Our Ref: AB/113/25/AOO

Section 106 Town and Country Planning Act 1990
Application for Approval of Details to Satisfy an Obligation

Application to approve First Schedule Clause 4 (Public Open Space Specification) in the Section 106 dated 26.11.21 (as amended) in relation to planning permission AB/135/20/OUT.
Land at Ford Road Arundel

DRAWING NO: Q8969_E

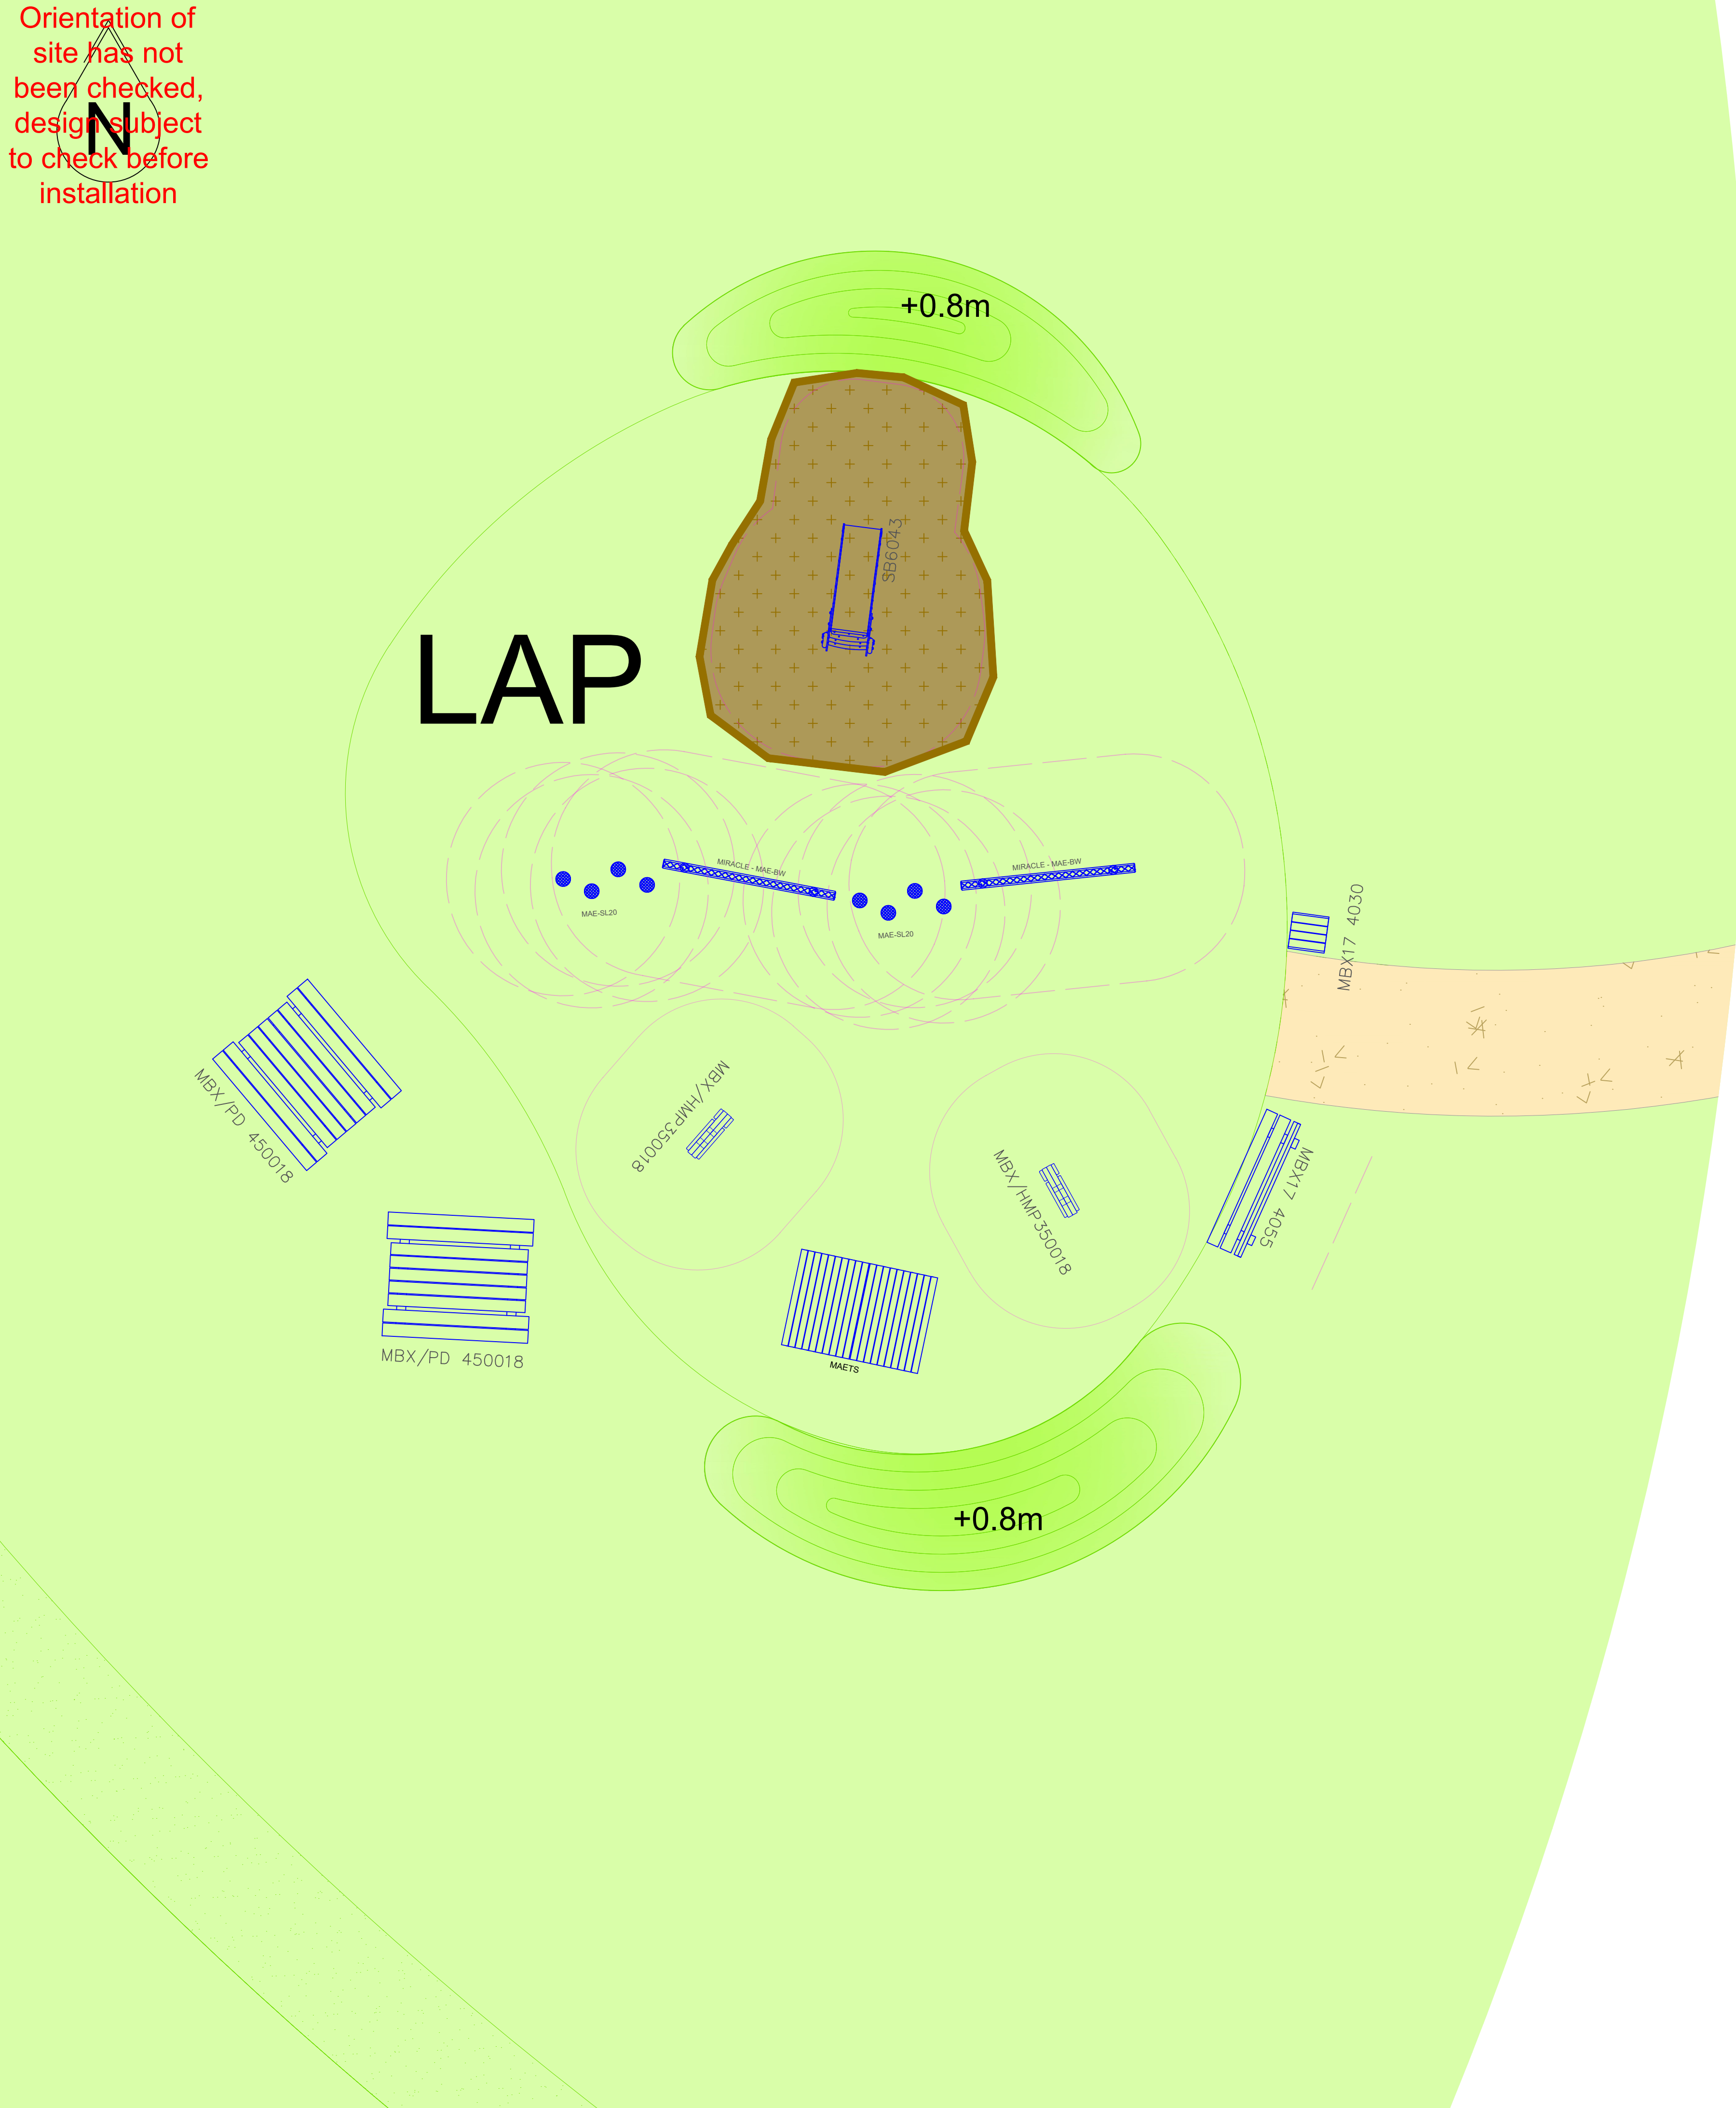
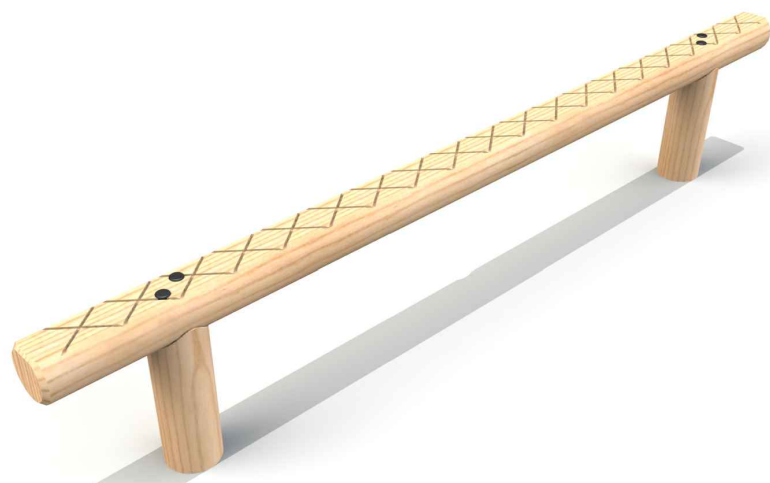
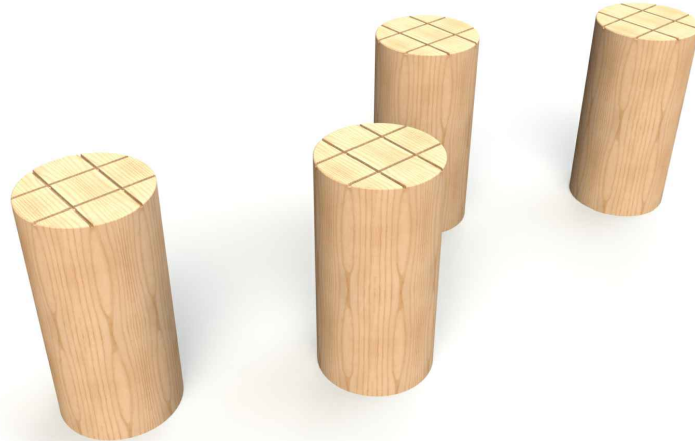
- LAP 1 surfacing: Rubber crumb surfacing has been replaced with bark mulch to the slide area, representing a further downgrade. Loose-fill surfacing is not supported by the LPA due to contamination and maintenance concerns. All other previous concerns remain unchanged.

DRAWING NO: Q8969_G

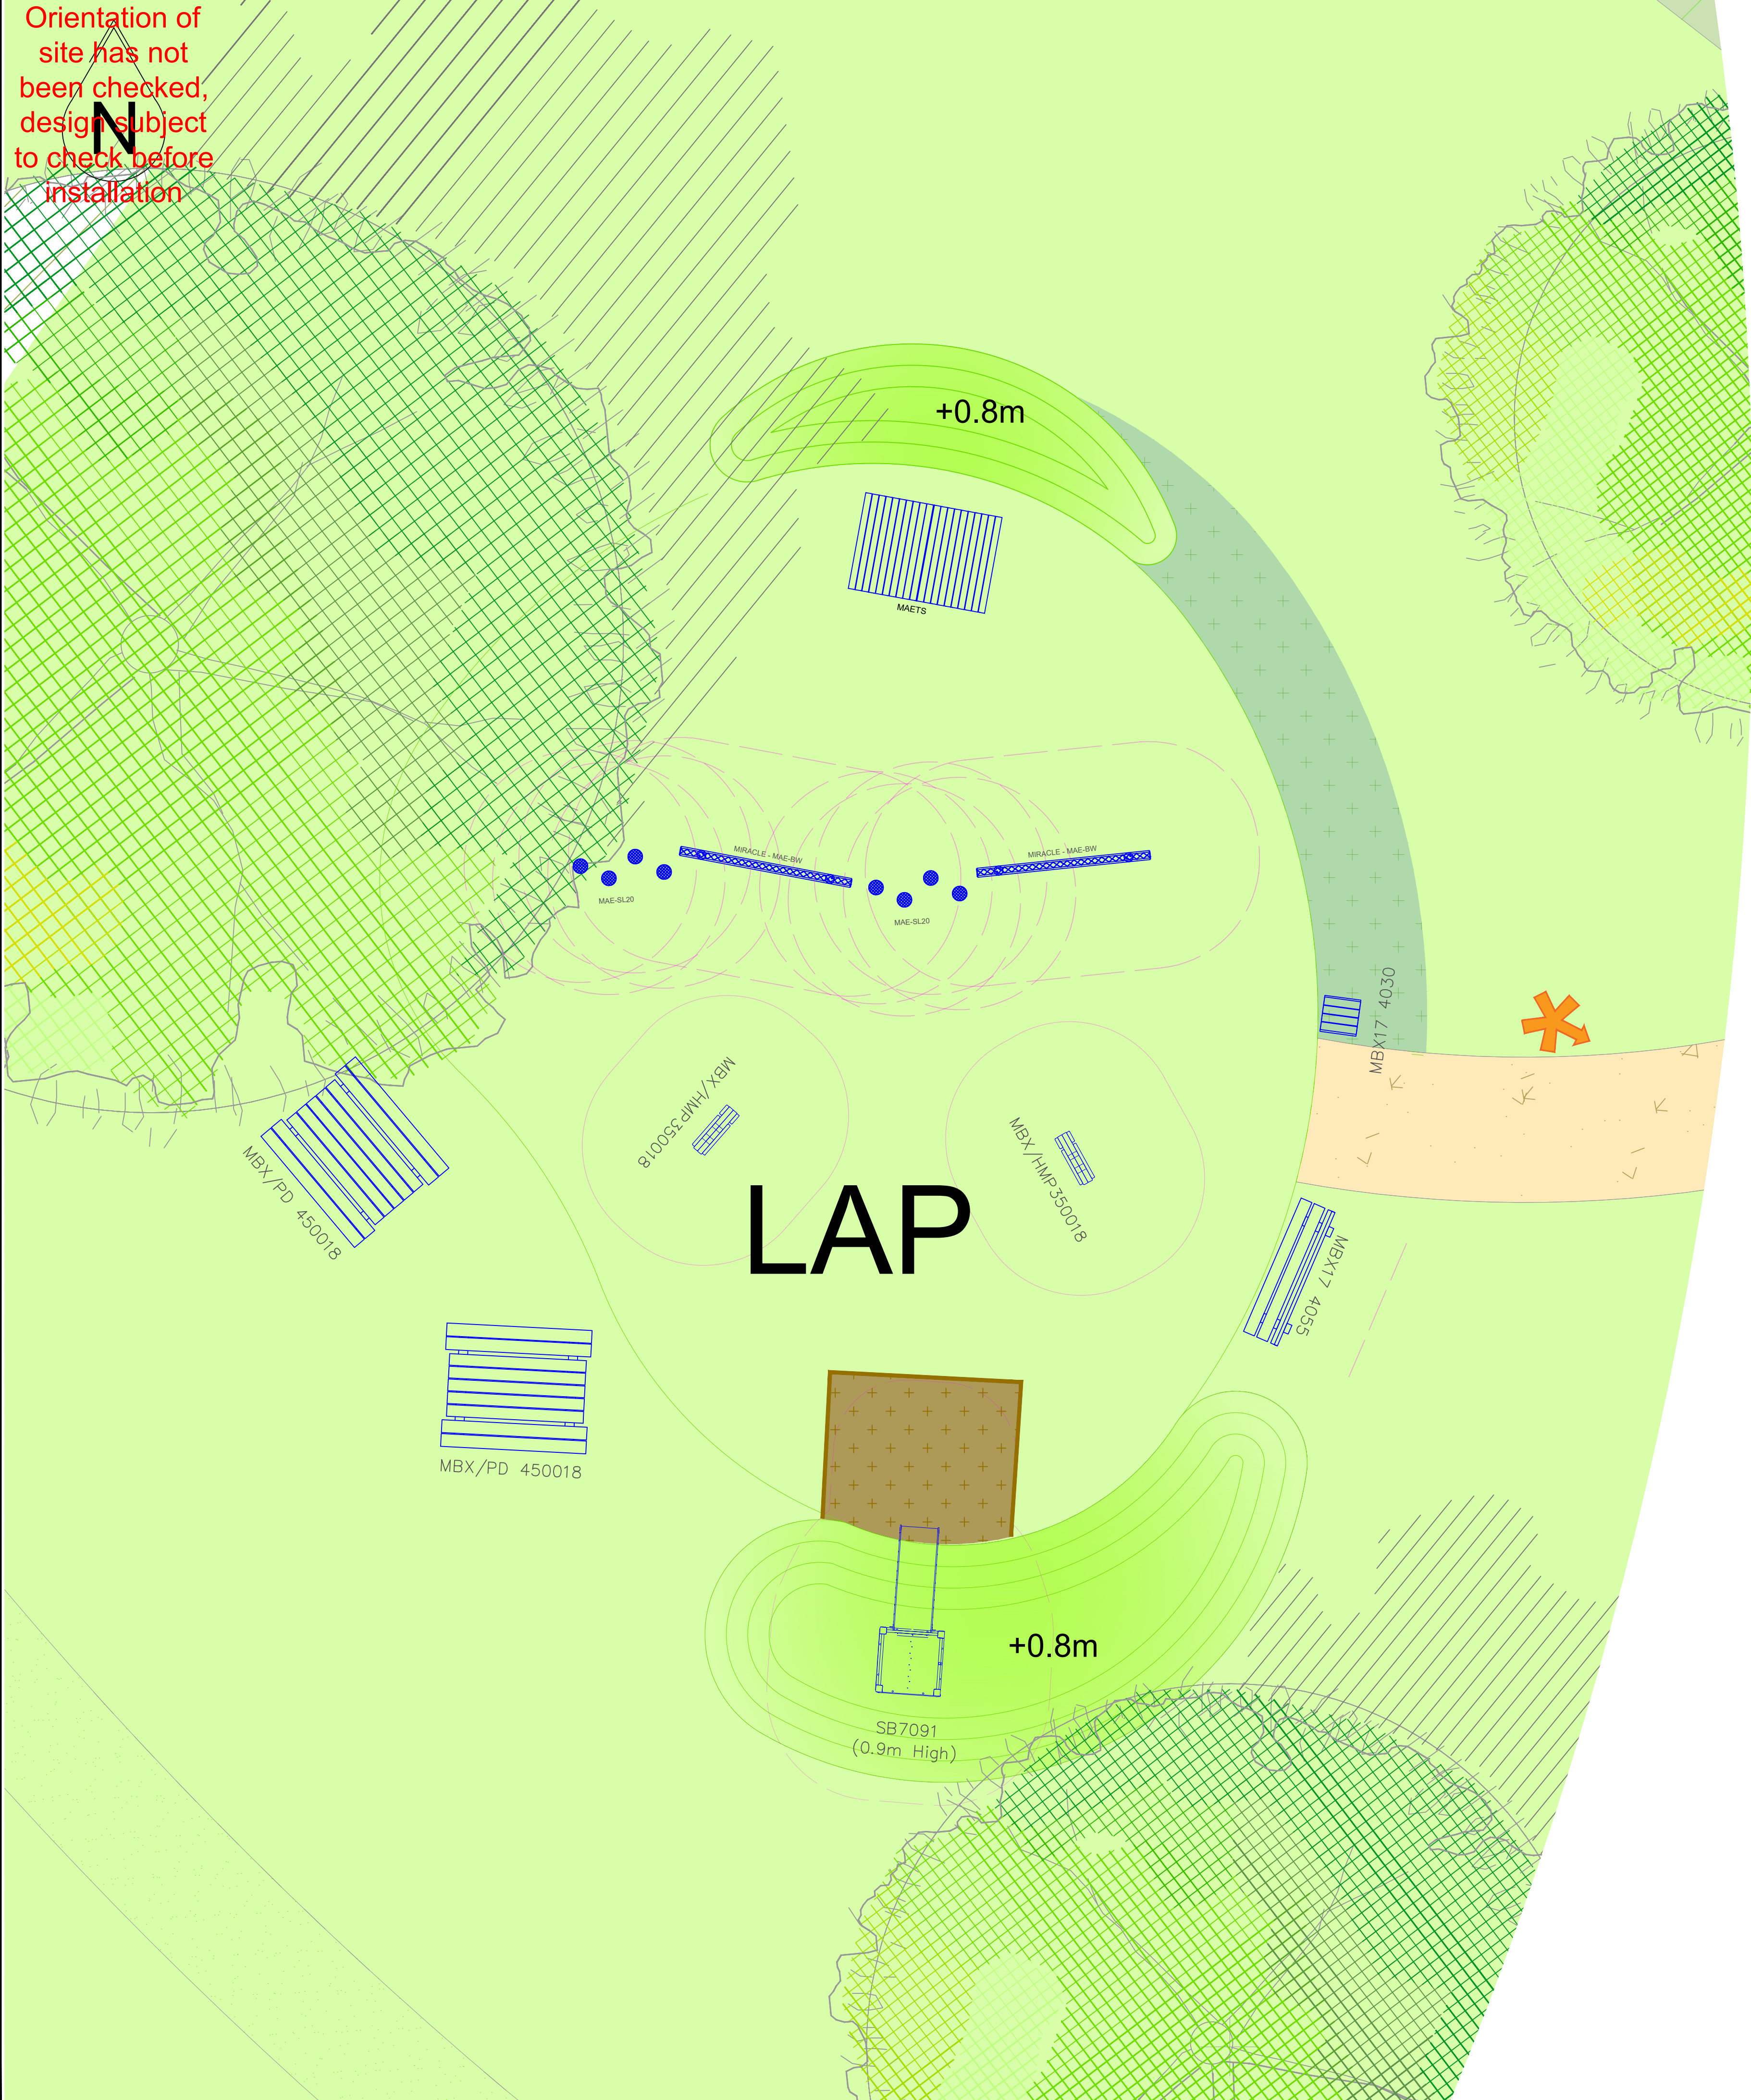
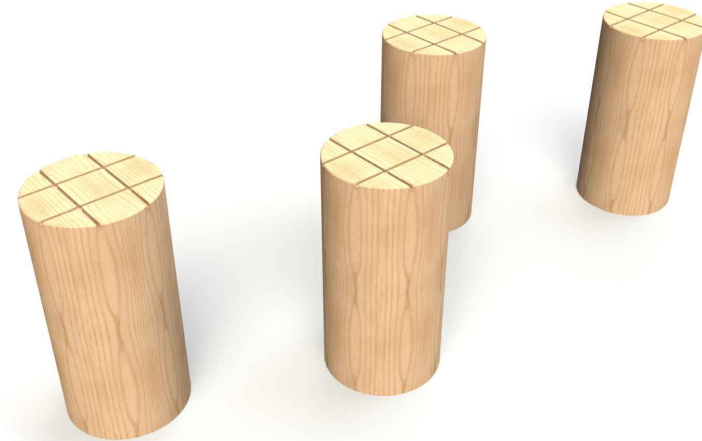
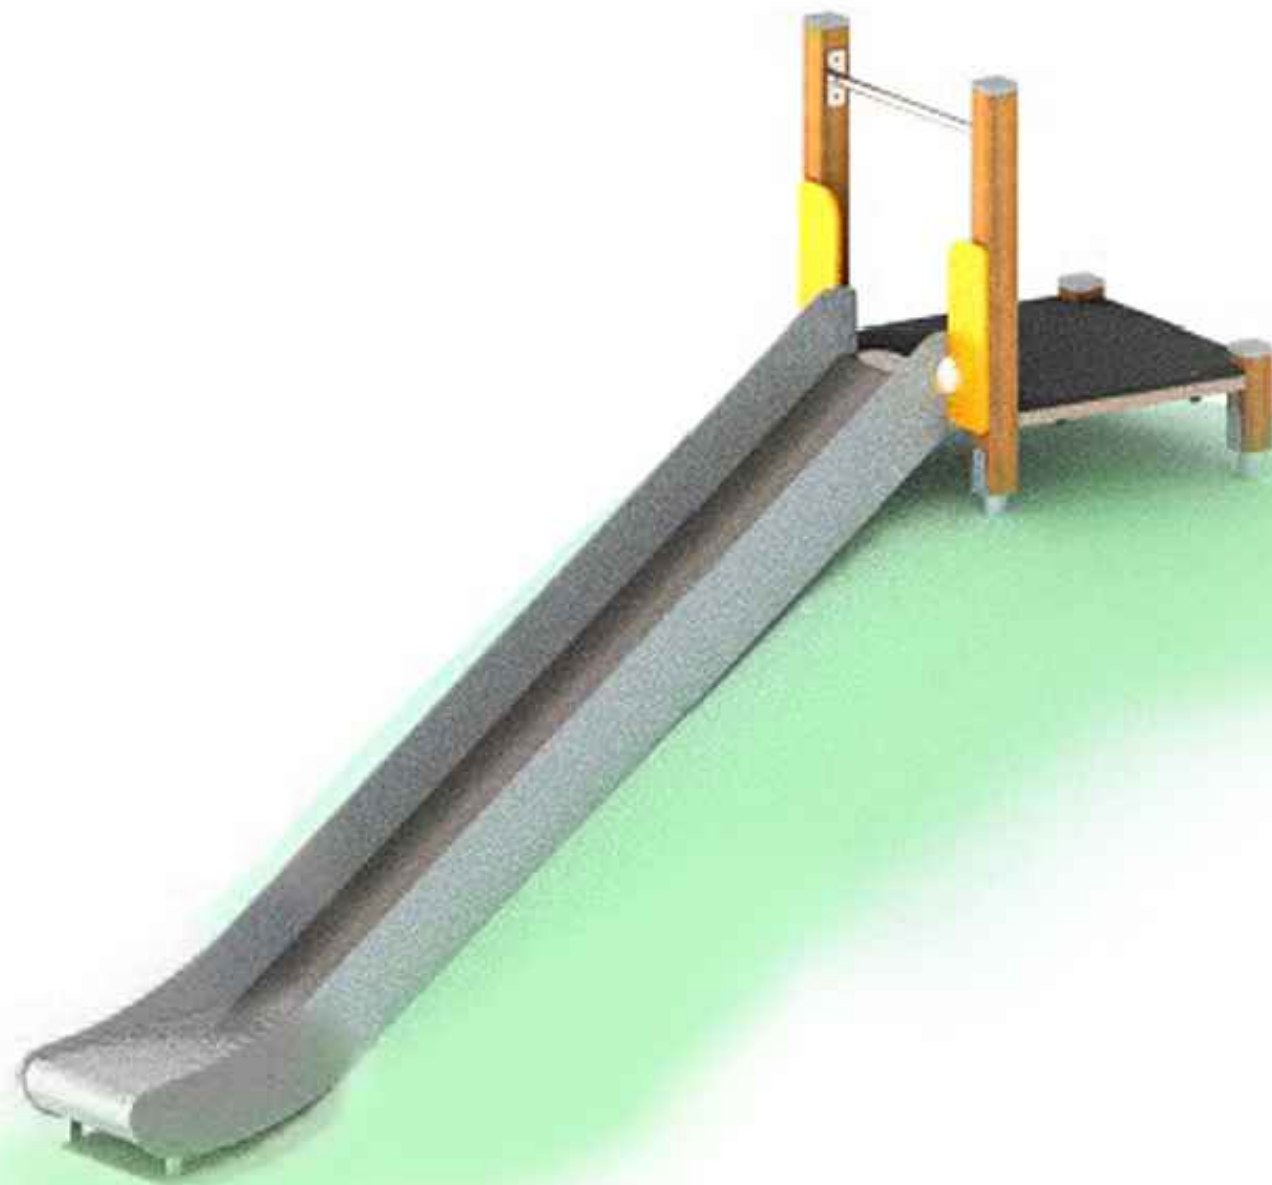
- LAP 1: Swing omitted and replaced with a slide; no details provided for enclosure or boundary; limited surfacing shown (only to slide); slide poorly integrated into landscape; lack of planting results in an exposed, low-quality and unwelcoming space.

- Soft landscaping: Updated softscape plans do not align with LAP 1 perimeter planting details. Landscaping within the LEAP remains absent, and previously approved planting around picnic tables is still omitted.

The loose wooden bark surfacing was approved under the Reserved Matters Application AB/106/22/RES (Hardscape Plan 2/4 AG-EDL-XXDR-L-0106_P2), as such the amendment of the surfacing to rubber crumb does not cause concern. Other amendments to plans include an increase in planting within the play areas, the addition of landform including a

slide and confirmation that fencing to the play areas is not required, as the SuDS ponds are fenced and road are well screened. Further details including an overall play spaces site plan and maze details have been provided.

As the majority of the comments raised have been satisfied the details can now be considered acceptable. Details and a specification of the play spaces have been provided. The correct number of plays spaces are provided and each space has suitable and age appropriate equipment.
